Our Case Number: ABP-318758-23

Re: Proposed public realm improvement works known as the "Westgate 2040 Project"
in Drogheda, County Louth

We are John and Tracey Murtagh, the proprietors of Old Abbey Dance Studios, situated on Old Abbey Lane in Drogheda.

DRAWINGS
Section A'-A' - George's Street to Old Abbey Lane

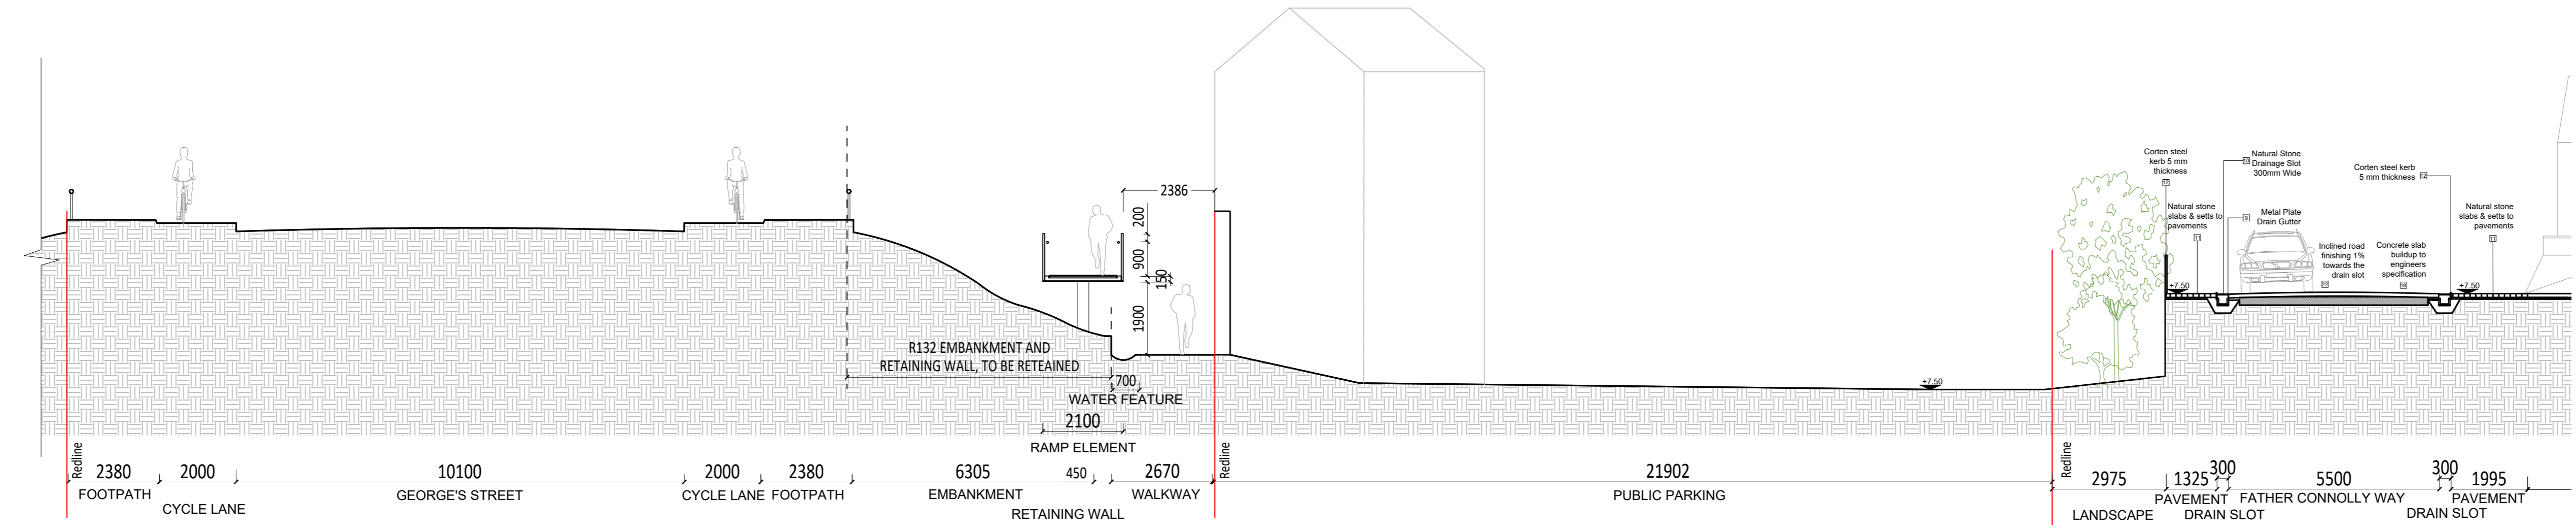
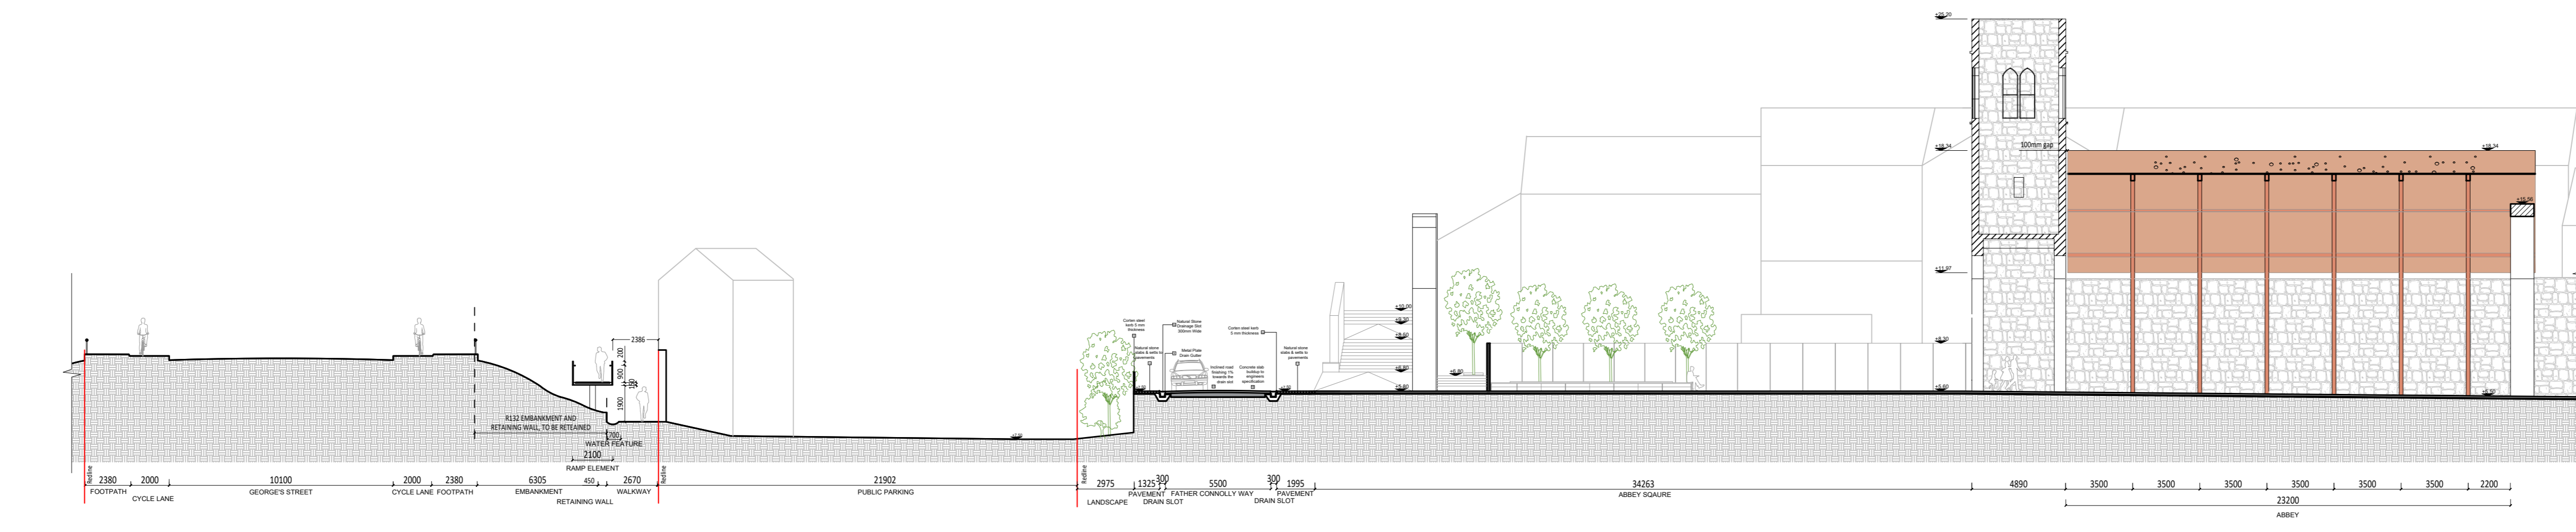
The identity and flexibility of the roofed space in Old Abbey Lane are not fully understood.

A feasibility study for a similar project was commissioned around 2010 to facilitate the use of Old Abbey Lane as a covered space for performances. At that time, it became evident that facilities such as toilets, bar/food preparation, power supply, storage for seating, backstage amenities, sound desks, and speakers would be necessary for these performances to take place. Since these essential facilities are not proposed in the current submission, the space does not seem usable unless this equipment is brought in. Given that the process of creating an event is unclear, and the location of these key elements is not specified, we would have concerns that the roofed element will only be utilised on a small number of days, leaving it unoccupied for up to 50 weeks of the year.

Heaviness of the roof will block daylight to the studios.

The roof structure will tower over our building, and this will have a significant impact on the quality of the Dance Studio spaces. A substantial effort was made during the Studios design to position our building back from the medieval arch, while opting for a complete glass wall to the front to ensure an unimpeded view. The proposed structure will obstruct light and the view to these spaces. No detailed cross-section has been provided for the roof structure, but it is evident from the existing cross-section that our view will be obstructed by a sheet of corten steel in front of the dance studio glazed front. We believe that with careful design, these issues could have been resolved, but currently, there is no resolution in place.
